**Consultation Response from KC,
Highways Development Management**

2023/93010 33, Wellington Street, Batley, WF17 5JE

Change of use and alterations to convert first floor store to flat

Date Responded: 06/12/2023.

424 SITE PLAN
SCALE 1:500
DRG No 23/139

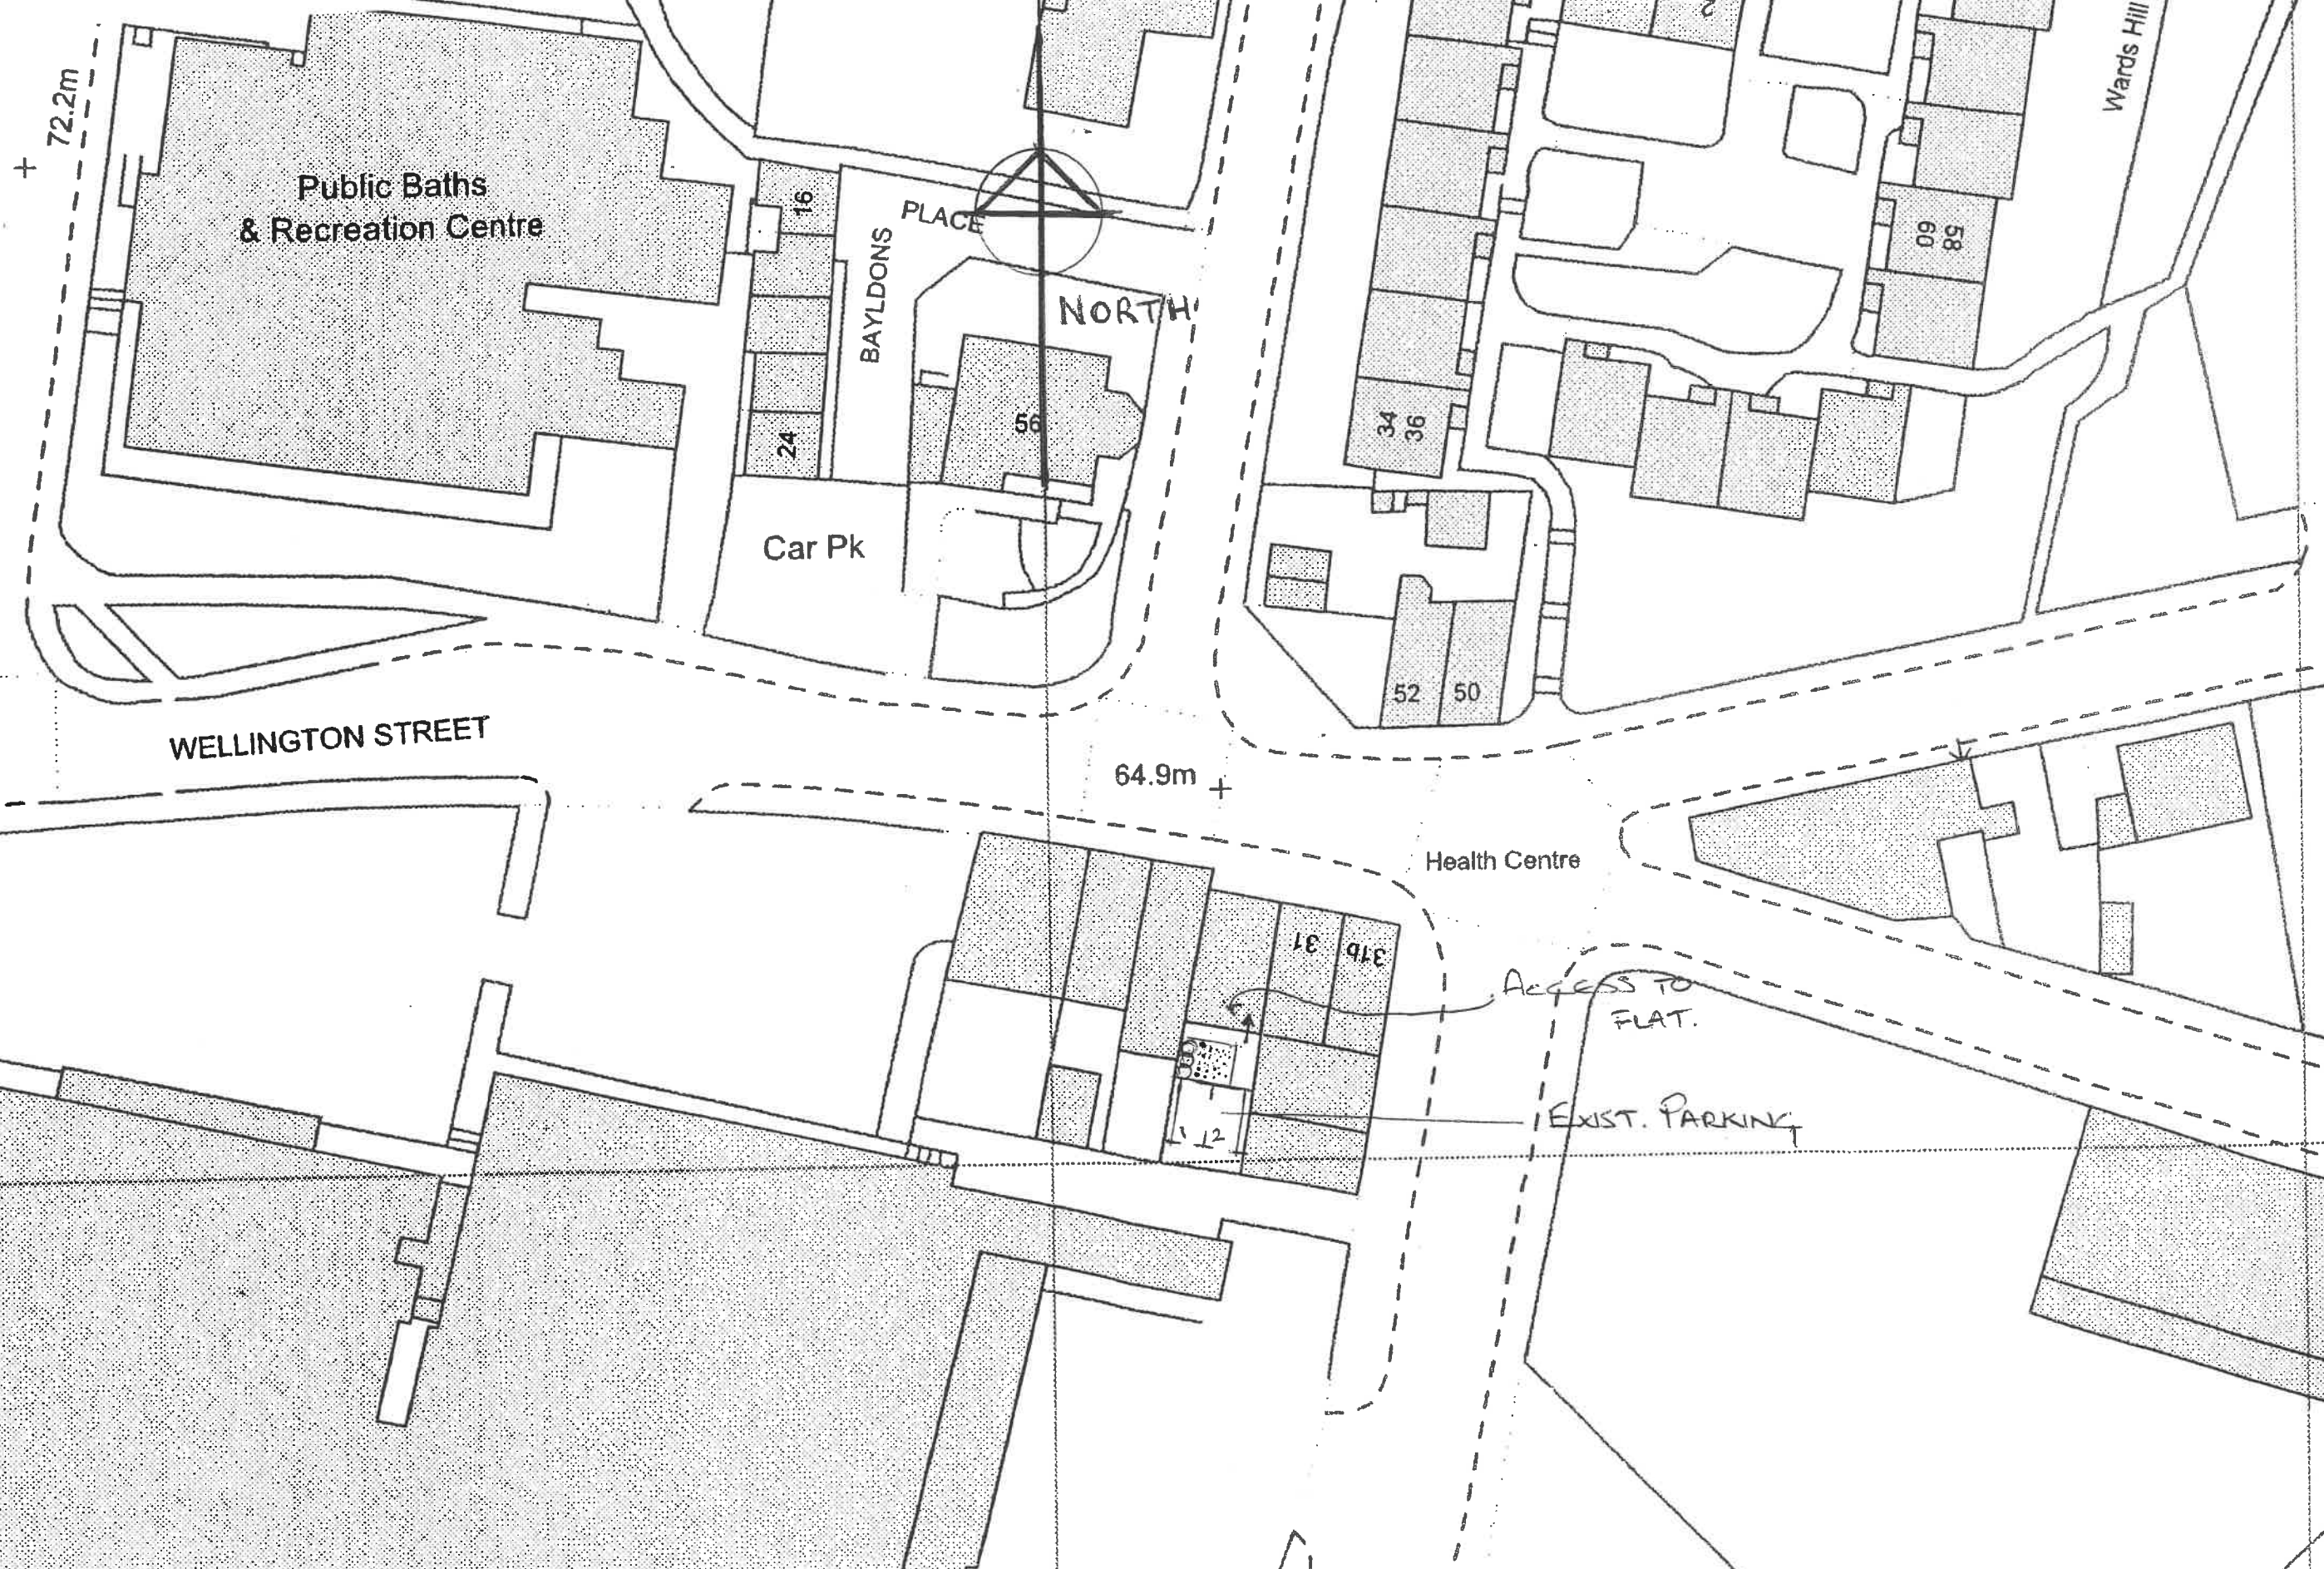
The site is situated in a highly sustainable location close to the town centre of Batley and has 2 existing off-street car parking spaces for the shop and the proposed flat which meets the recommended parking standards.

The approved vehicle parking areas will need to be surfaced and drained in accordance with the Communities and Local Government; and Environment Agencies 'Guidance on the permeable surfacing of front gardens (**parking areas**)' published 13th May 2009 (ISBN 9781409804864) as amended or superseded.

From a Highways point of view, subject to 3 of the 5 parking spaces shown as the proposed parking layout on Drawing no. 517.1 being made solely for the use of any future residents, Highways Development Management would raise no objection to the proposal. Given that there are traffic regulation orders in place to prevent indiscriminate parking in the vicinity of the site, numerous public
